DECISION DELEGATED TO HEAD OF PLANNING

Application No:	H21-0986-23	Applicant:	A Trett
Proposal:	Details of site levels & floor levels, scheme to deal with contaminated land, foul & surface water disposal, scheme of landscaping & tree planting (including screening of bin collection points) & boundary treatments (Conditions 3, 4, 5, 6 & 7 of H21-0537-23)		
Location:	Land West Of 1 East Road Tydd Gote Wisbech		
Terminal Date:	2nd January 2024

Planning Proposed Site Plan
1 : 200

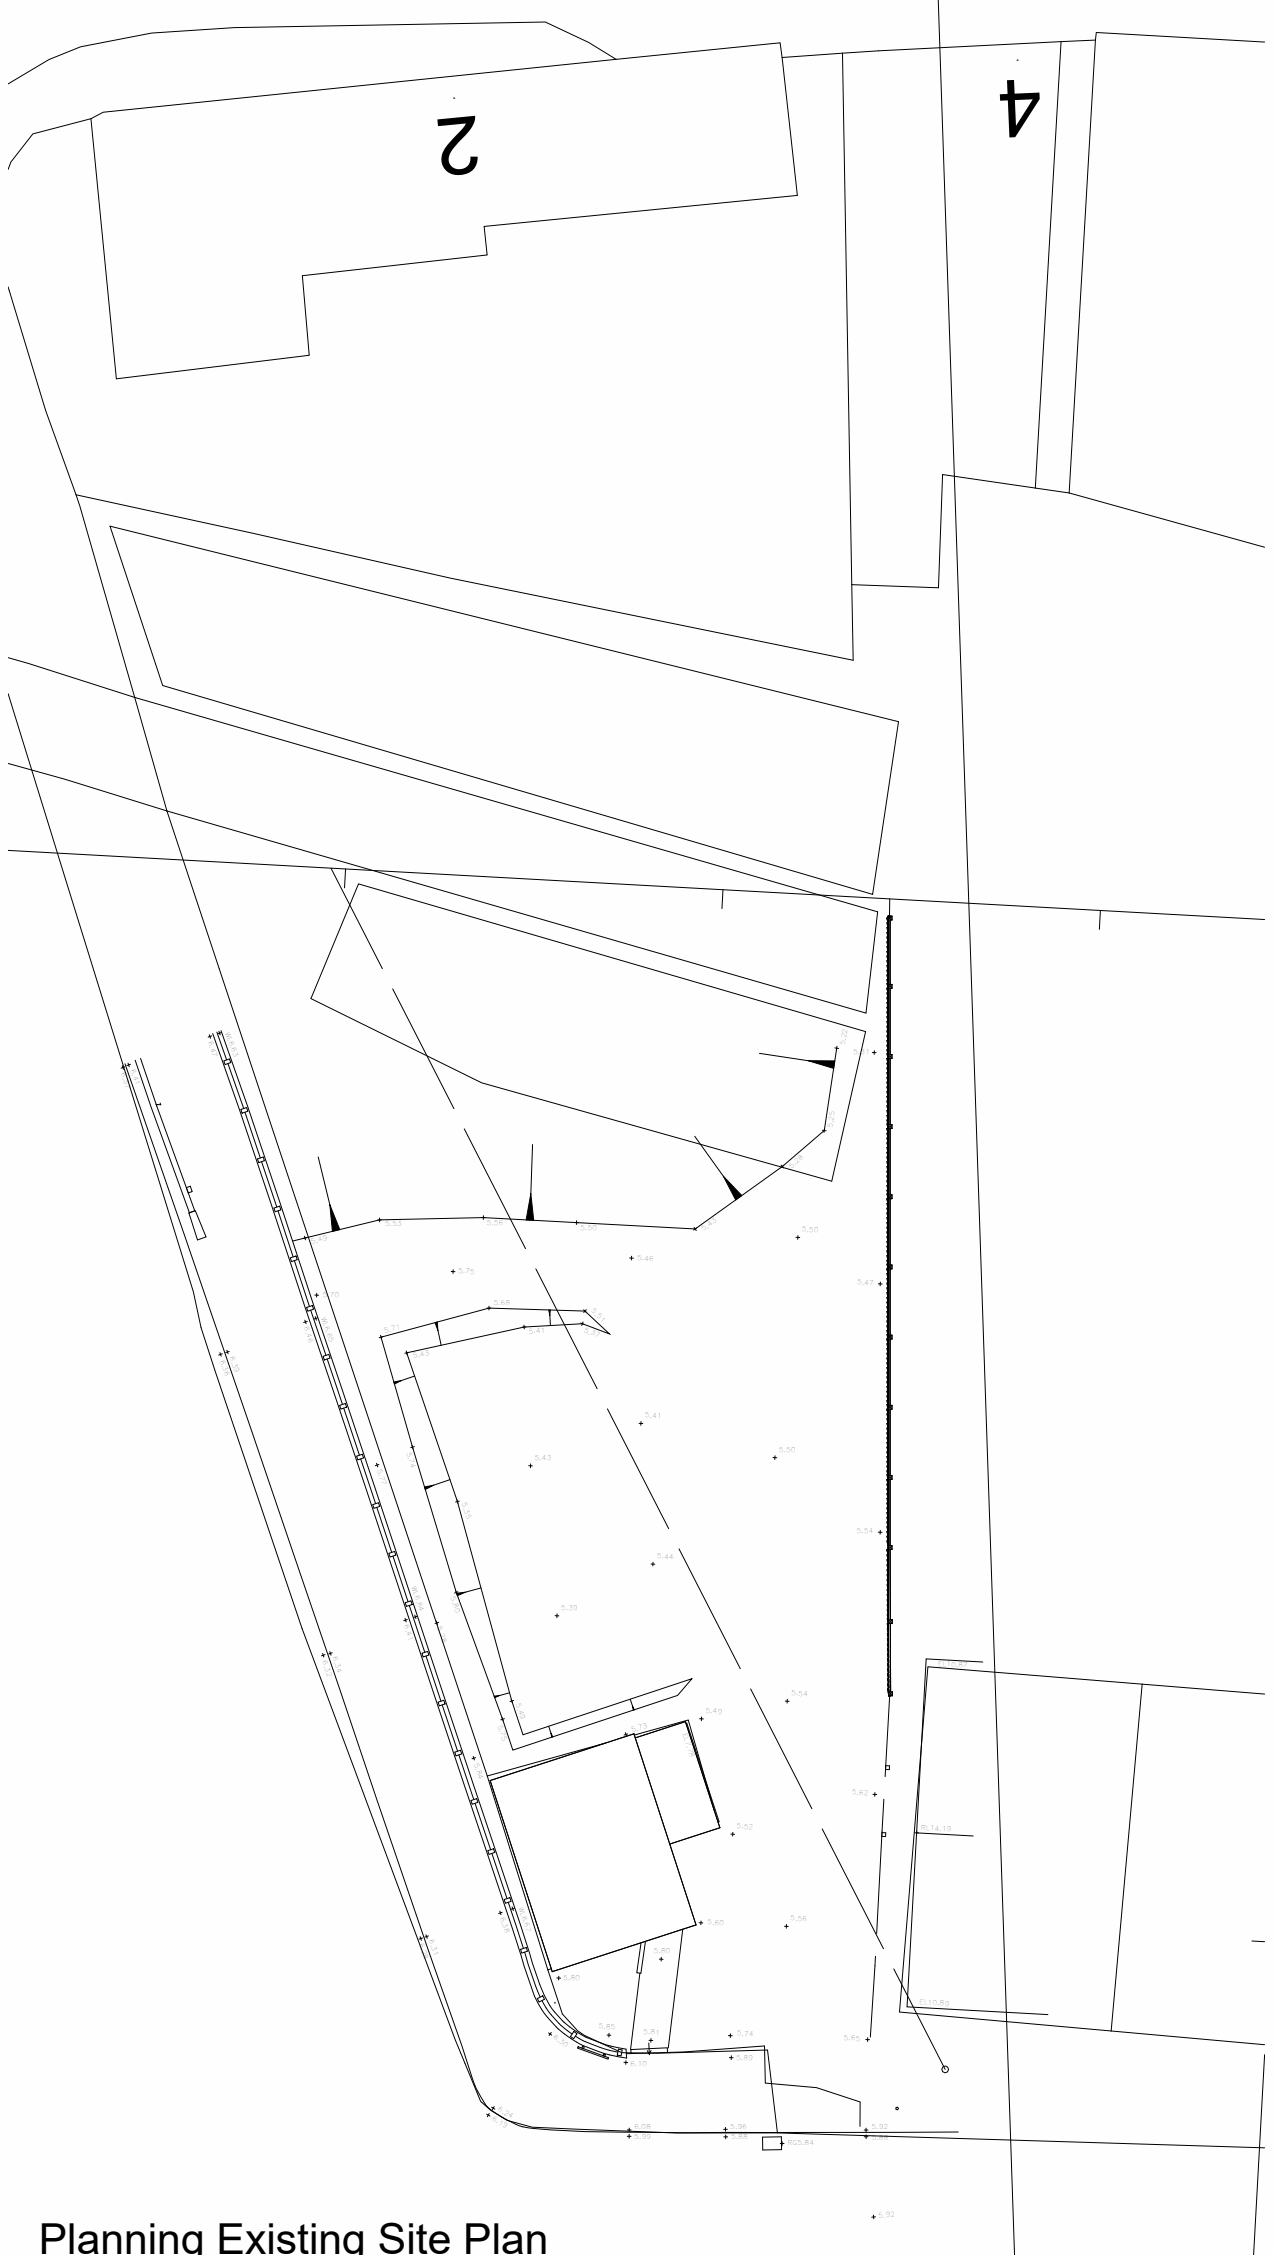
The applicant proposes no planting other than the proposed turfing of the rear gardens of the properties. Typically, this would not be permissible, as a failure to satisfy the requirements for Biodiversity NET Gain. However, in this instance, the proposed development is within a Drainage Board easement, where planting other than turf/grass is not permitted, in order to avoid adding to

drainage issues. Therefore, in this instance, the proposed scheme of planting is considered to be acceptable, and therefore, condition 6 may be discharged.

Due to the location of the site on a drainage board easement, no boundary treatments are permitted except for the metal handrail at the top of the bank which was included within the original application. The proposal for a handrail along the top of the bank is deemed to be acceptable and would have no material effect upon local residential amenity or the visual nature of the site and the proposed development. As such, it is considered that this condition may be discharged.

Drawing Title
Planning Existing Site and Location Plan

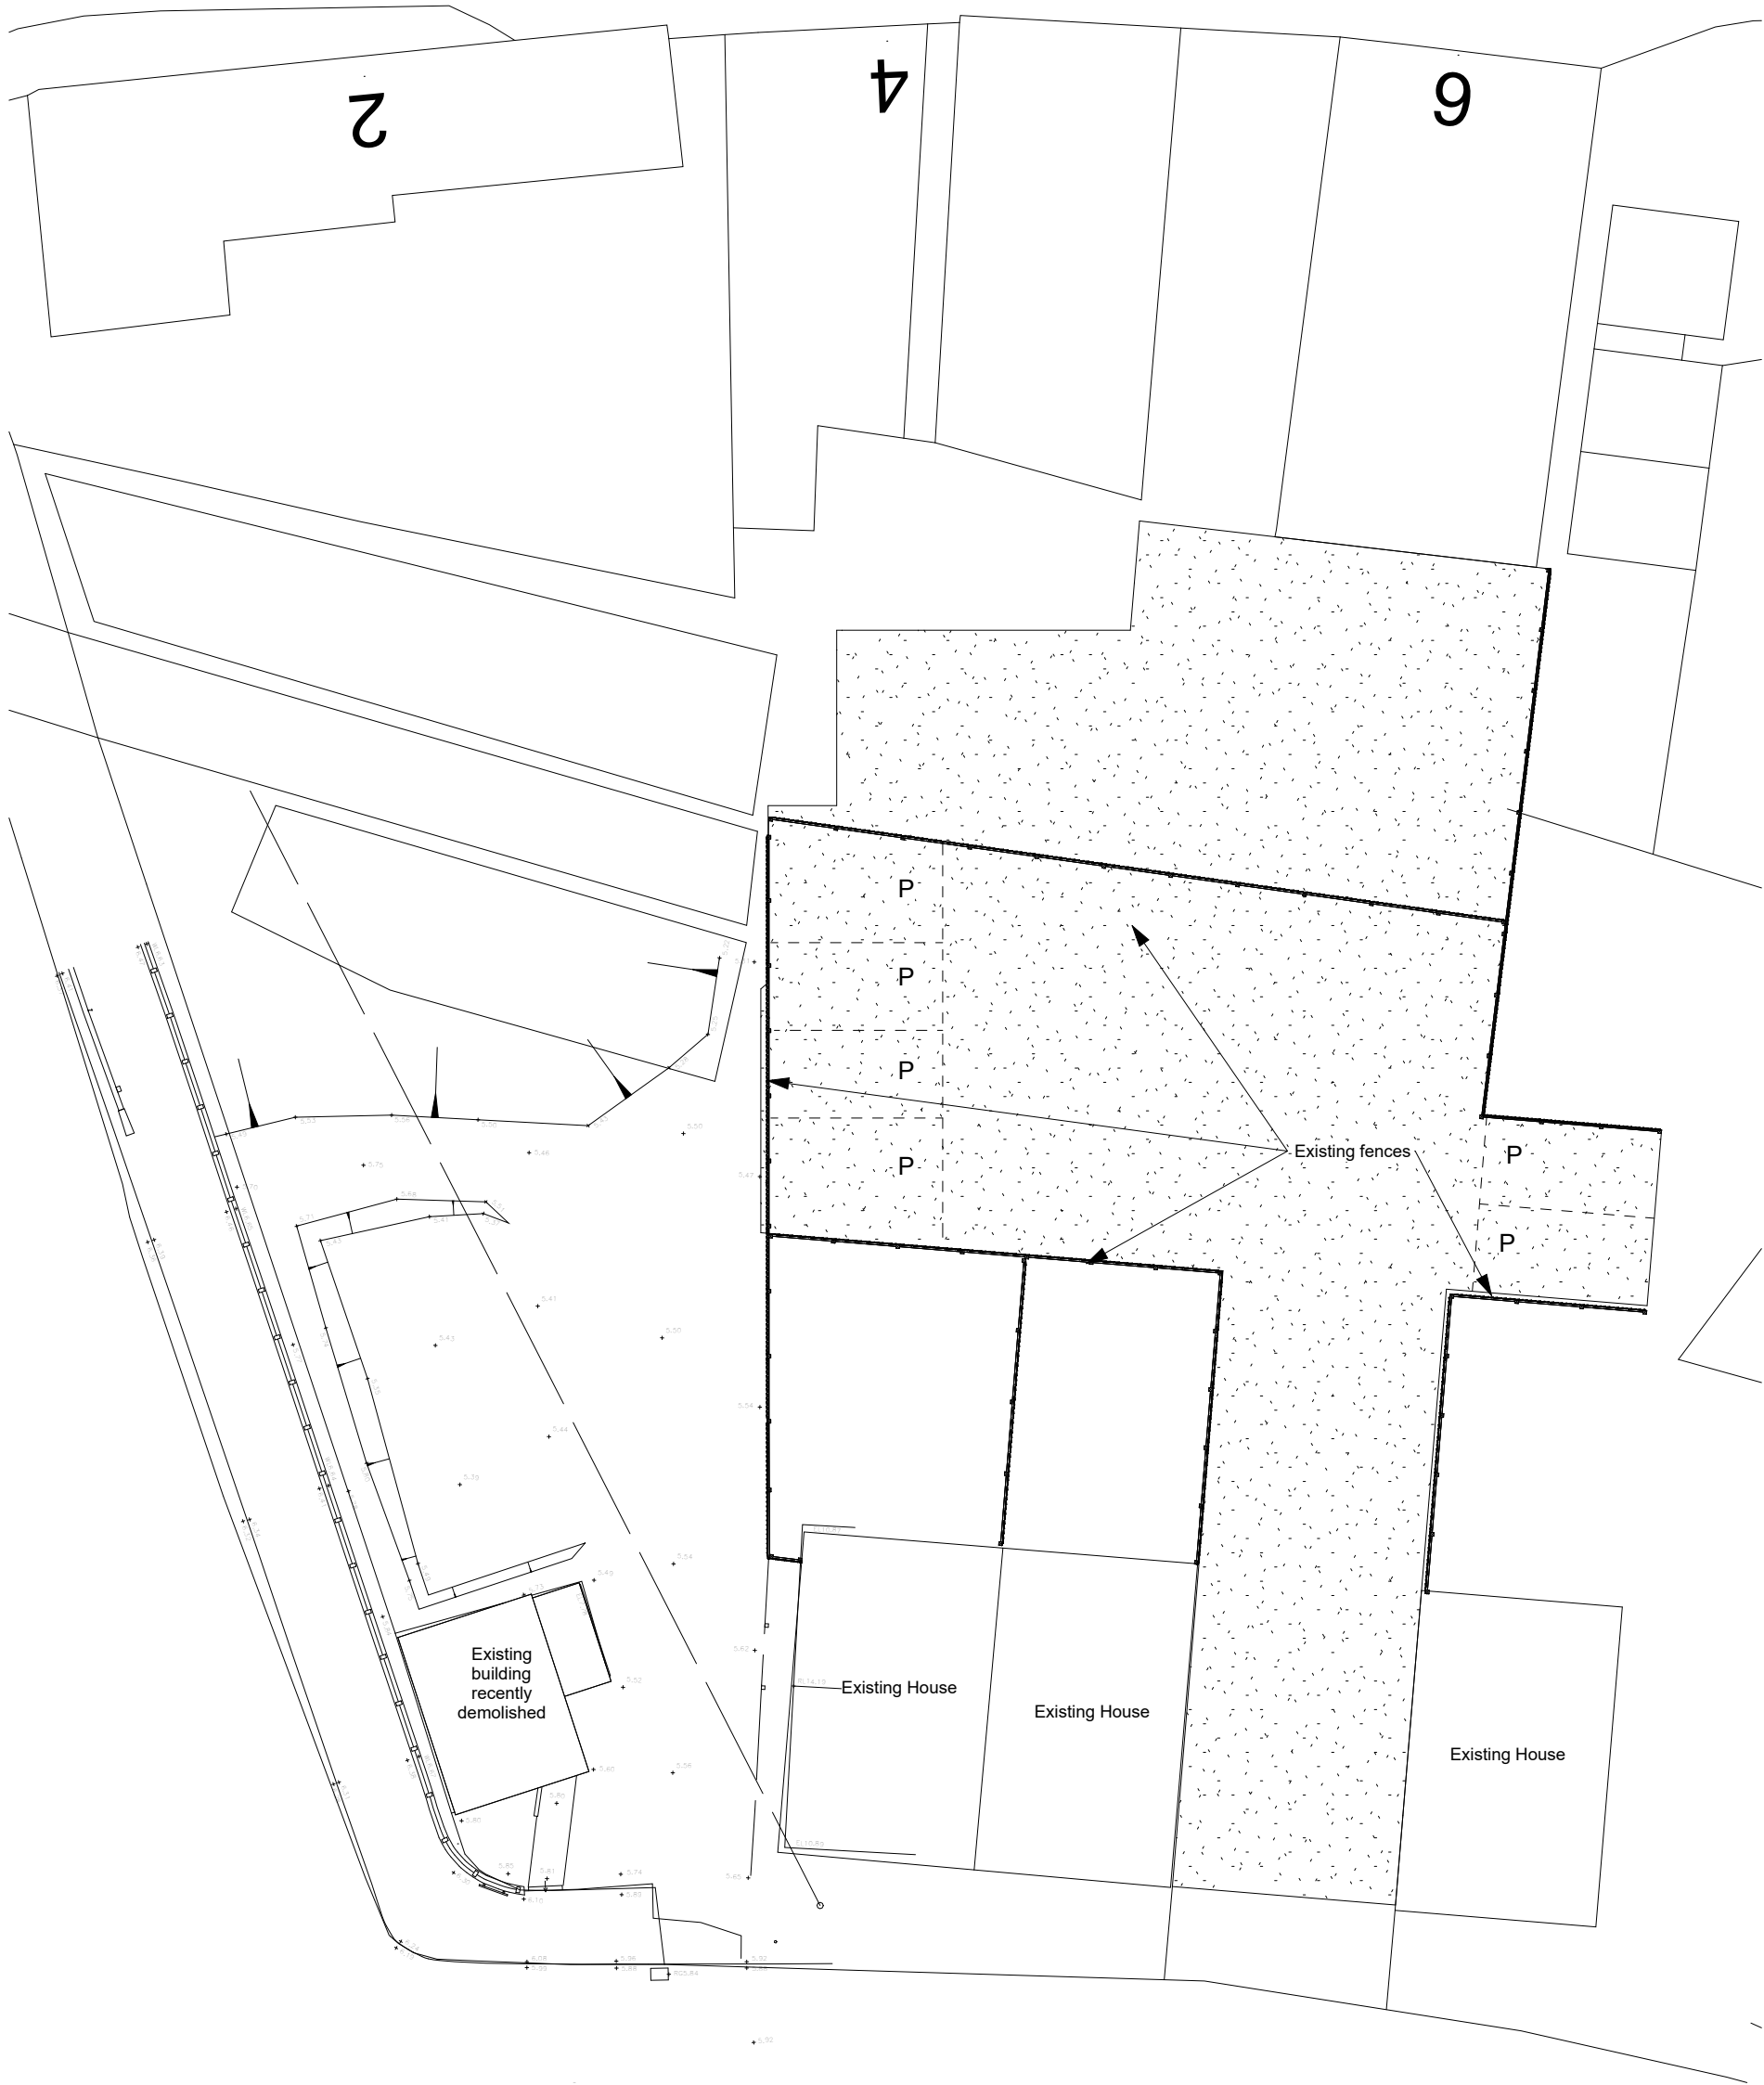
The proposed levels indicate that much of the site will remain untouched in terms of levels, although closer to the proposed property, ground levels will be raised by ~300mm, with the final finished floor levels to be ~300mm above that level, creating a total raise of ~600mm. The site as it stands sits substantially lower than neighbouring plots and similar raises have been permitted to the adjacent housing development. Resultantly, it is not felt that this proposal would lead to undue harm to nearby residential amenity, particularly because of the additional considerations, including; the distance of the proposed development from adjacent properties, and the lack of windows on the proposed development's easternmost facing elevation.

Furthermore, as the proposed levels would slope toward the drain to the north and the lack of objections from the local internal drainage board and LCC Lead local Flood Authority, it is not considered that there would be a harmful effect, via these proposed levels upon local surface water drainage.
